Comment for planning application 20/00841/F

| Location | <input type="text" value="Barn And Land South West Of Cotefield Farm Church Street Bodicote"/> |
| Proposal | <input type="text" value="Erection of garage adjacent to approved dwelling and change of use of agricultural land to residential use"/> |
| Type of Comment | <input type="text" value="Objection"/> |

DRAWING:
Plans Sections and Elevations

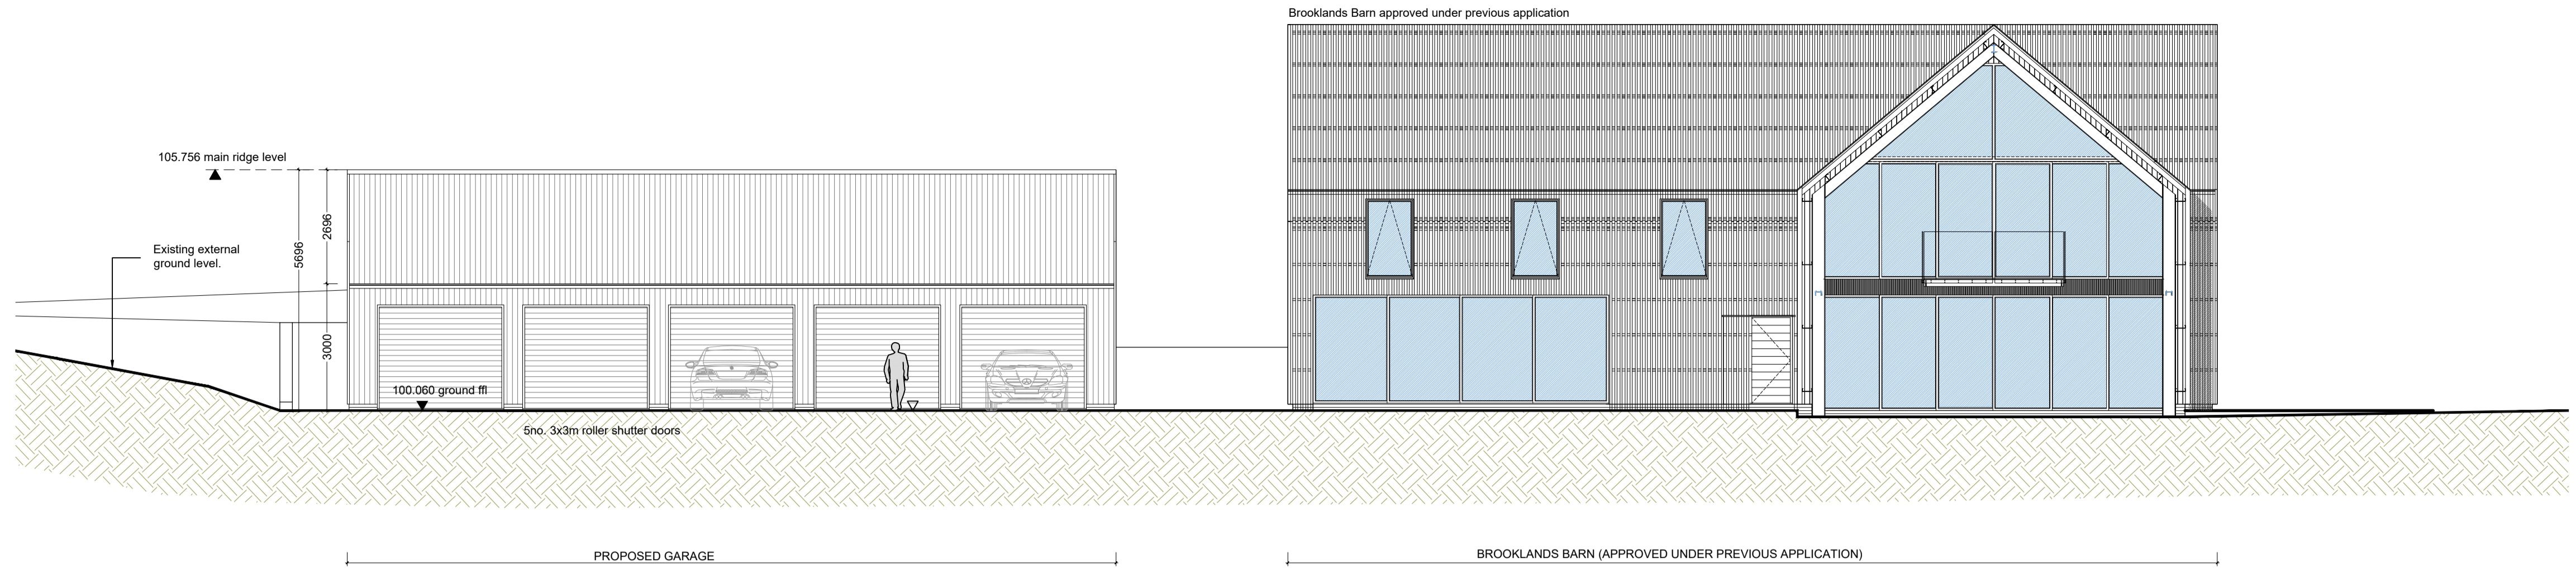
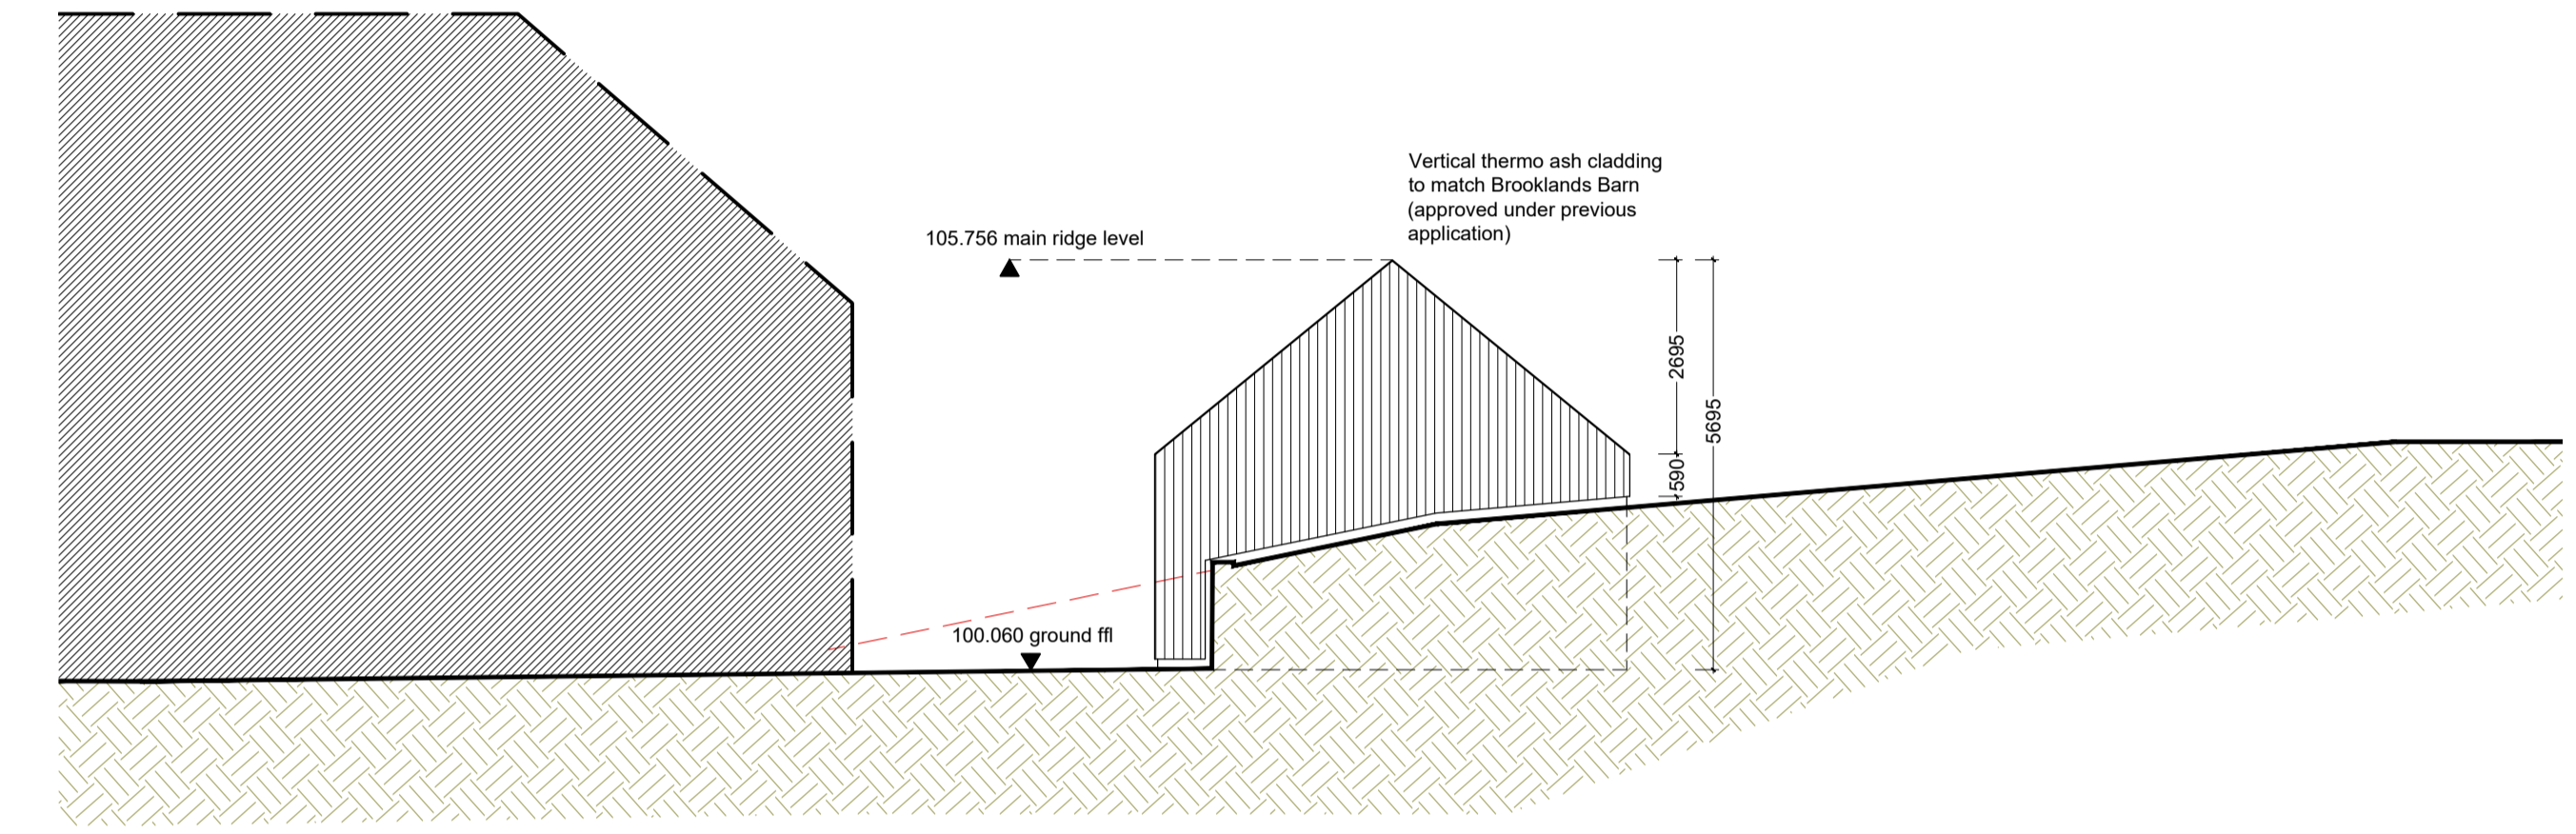
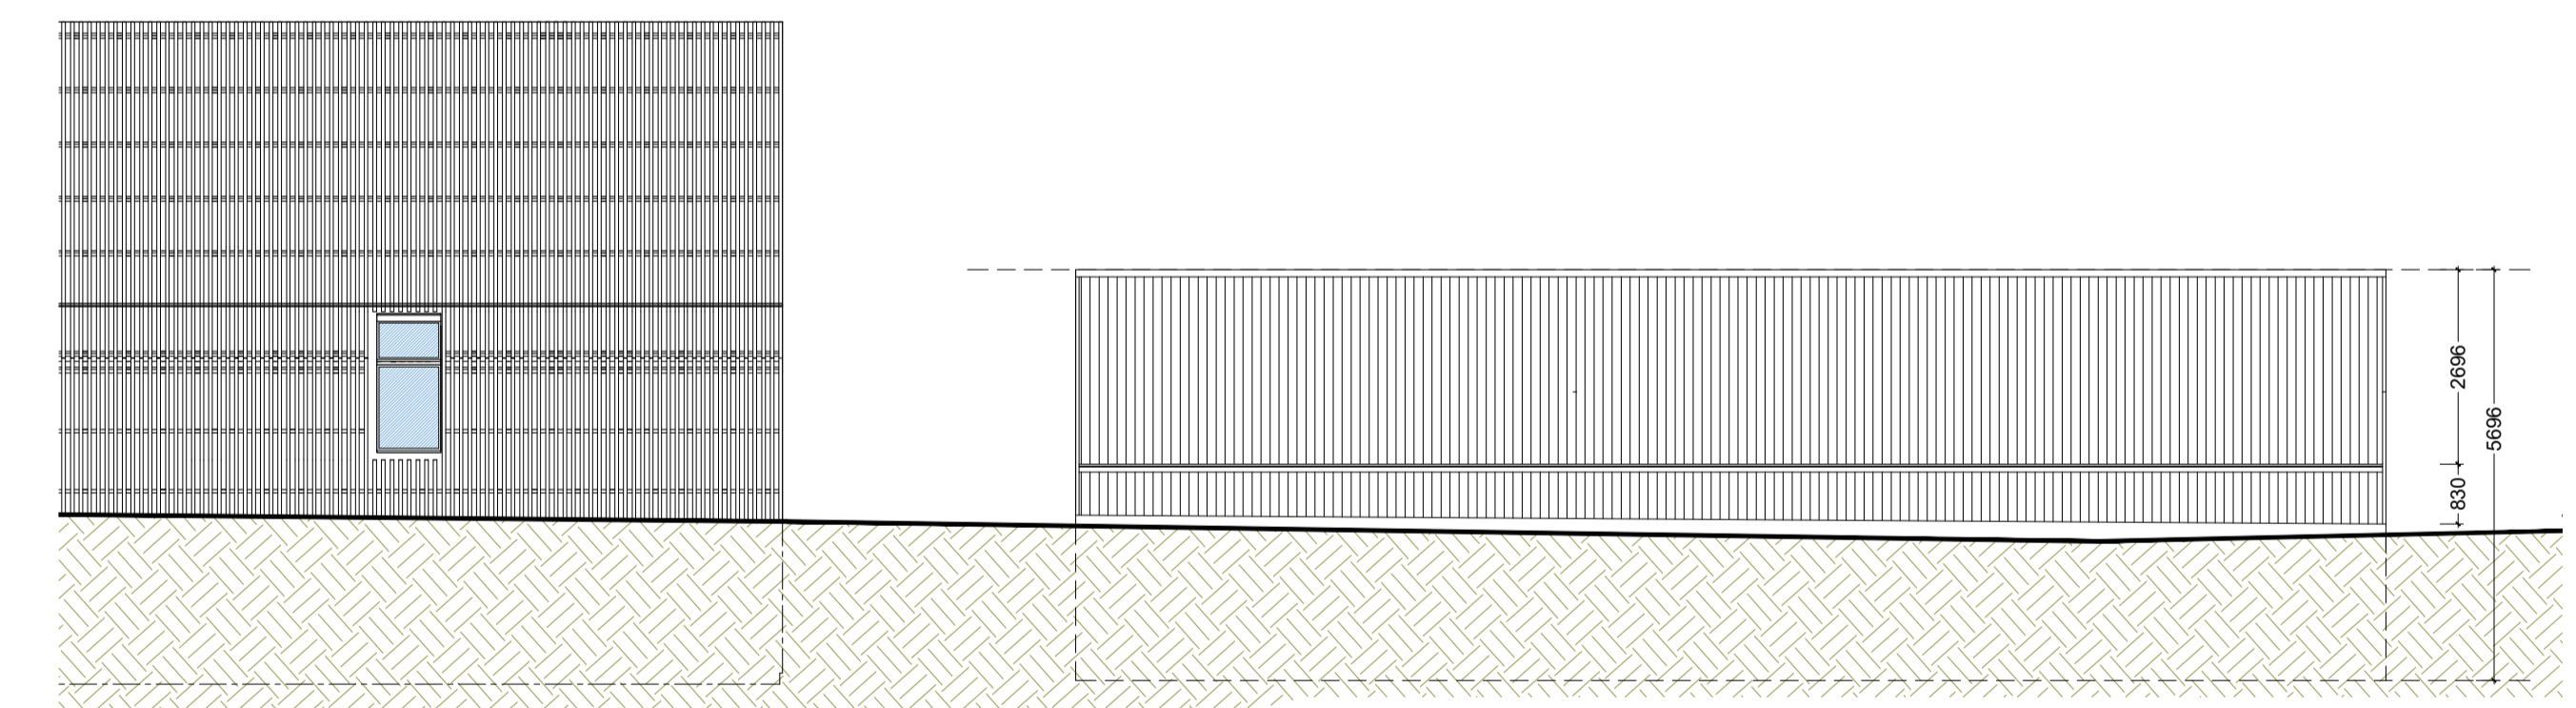
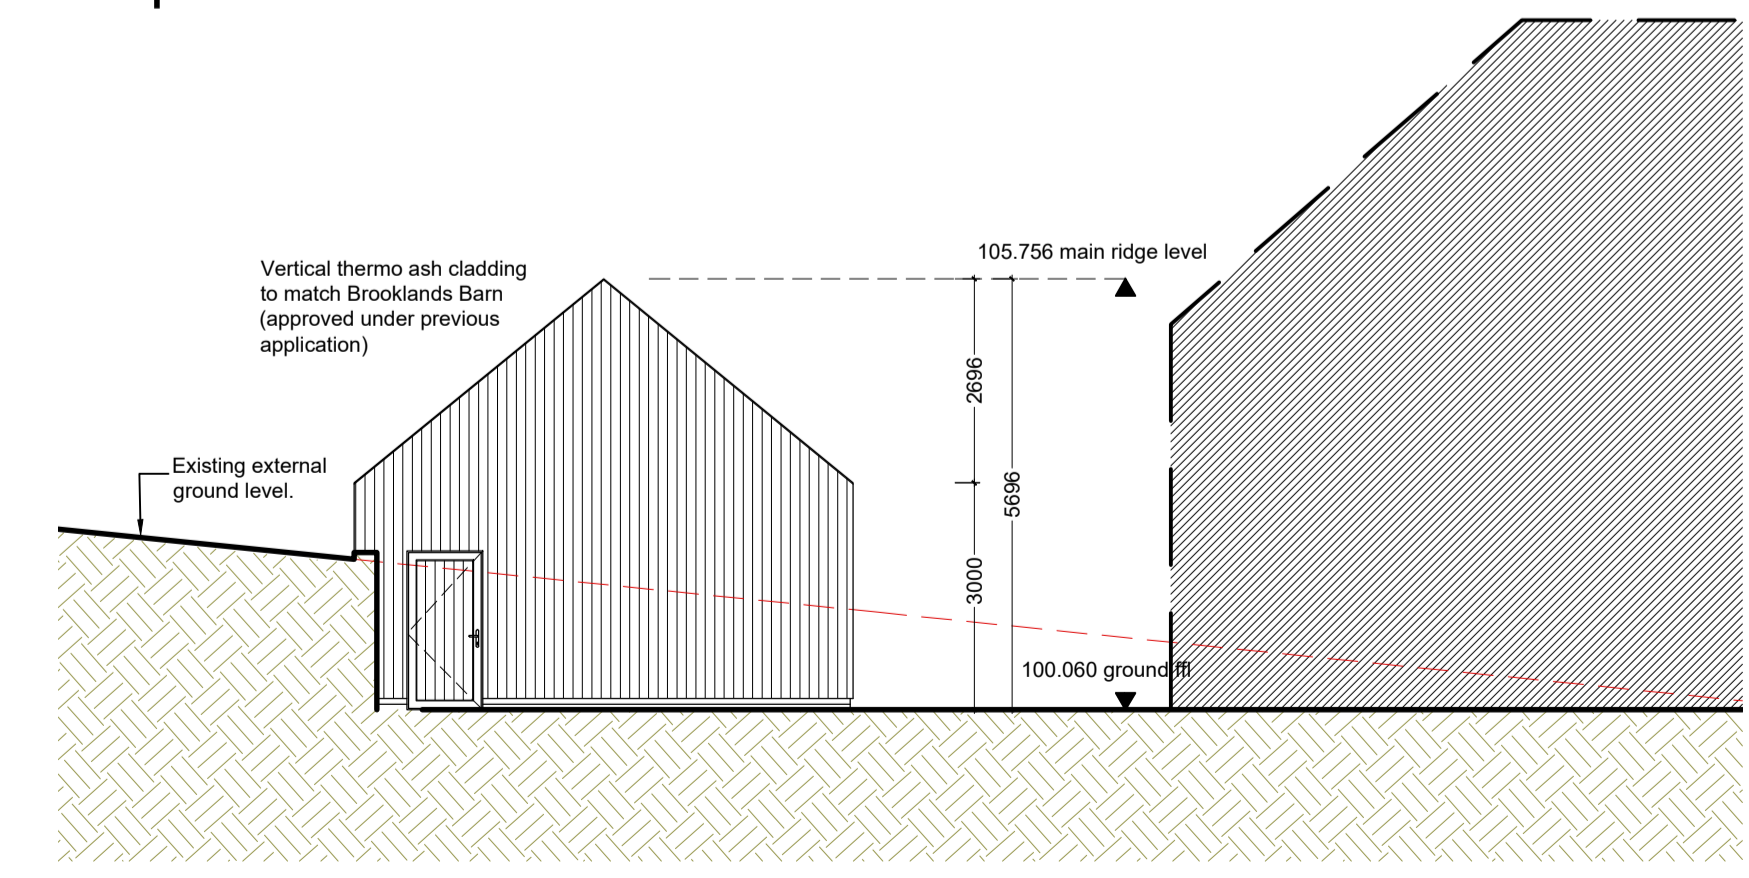
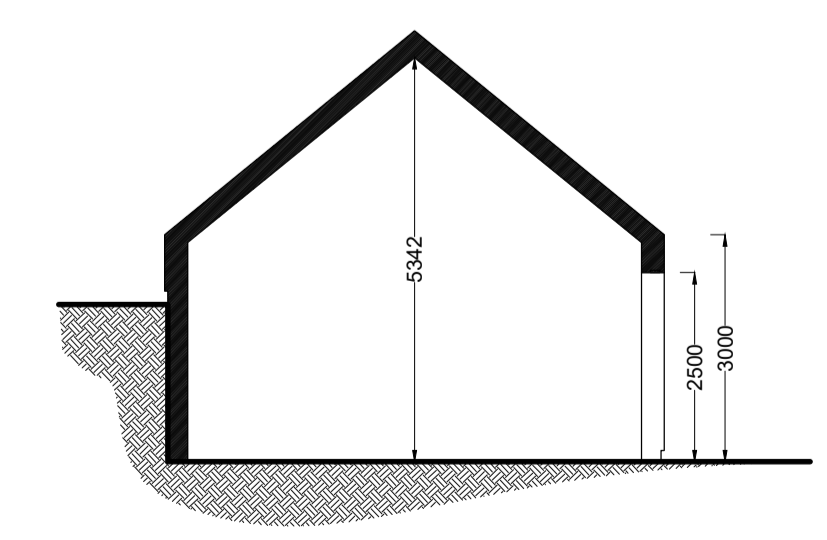
| Comments | <input type="text" value="Buildings are not in keeping with the rural landscape and, without substantial screen planting, they will be highly visible from the village and footpaths. The size, siting and design of the 5 garages are considered an unnecessary and excessive development for a residential property even allowing for the storage of grounds maintenance equipment. We believe this development would cause an unjustified visual intrusion into the valued rural landscape and open countryside. We understand this application is contrary to the provisions and aims of saved Policy C28 of the CLP 1996, Policies ESD 10, ESD 13 and ESD 15 of the CLP 2031 and Government guidance within the NPPF in respect of conserving and enhancing the natural environment."/> |
